Re: Proposed SHD, 280 no. apartments, The Meadows, Ballinure, Cork, Ref. 313216

The NTA has reviewed the subject proposed development and makes the following observations for the Bord's consideration.

# TRAFFIC ACCESS

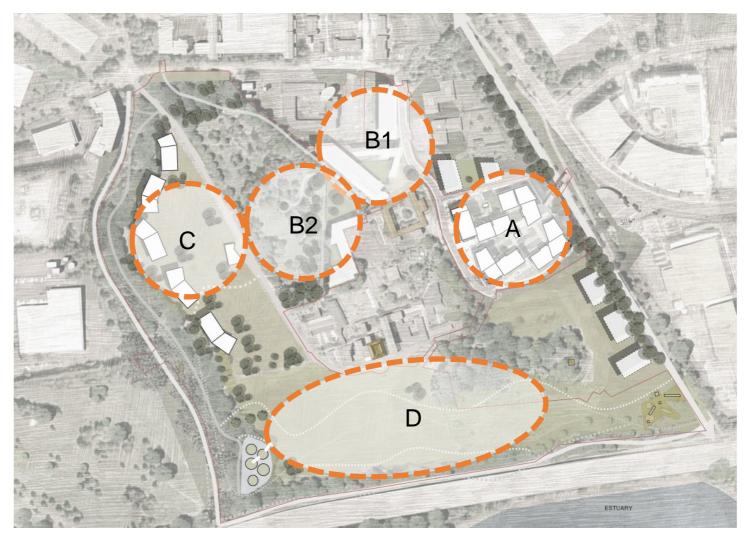
Route 20, as presented in the draft network redesign, would operate in a clockwise loop within the Masterplan area and accessing the area from Skehard Road. As the most effective way of directly serving all phases of development within the Masterplan area, the operation of this loop would in turn be dependent on the completion of a linking road from the Primary Existing Road Network in the vicinity of the subject proposed development and a route which connects back to the Bessborough Road, via the western side of the Masterplan area. The nearest connecting road is currently the existing 'Historic avenue', as indicated on page 28 (Traffic Access) of the Architectural Statement.

However, the current traffic access arrangements, as indicated, do not provide for connectivity between these two roads, or between the Primary Existing Road and the development access road as indicated for Phase 3, thus not providing for the proposed bus Route 20.

It is recommended that any decision to grant permission for the subject proposed development should be contingent on the necessary amendments being made to the internal road network within the Masterplan area, to ensure that a linking route is provided, enabling the operation of the bus route as proposed in the Draft BusConnects network redesign.

In addition, the NTA would recommend further consultation with Cork City Council and the BusConnects Network Redesign team to ensure that the necessary design matters, including the location of potential bus stops is taken into consideration in both the configuration and design of the

internal road network, serving the subject site and the development of the Masterplan area as a whole.
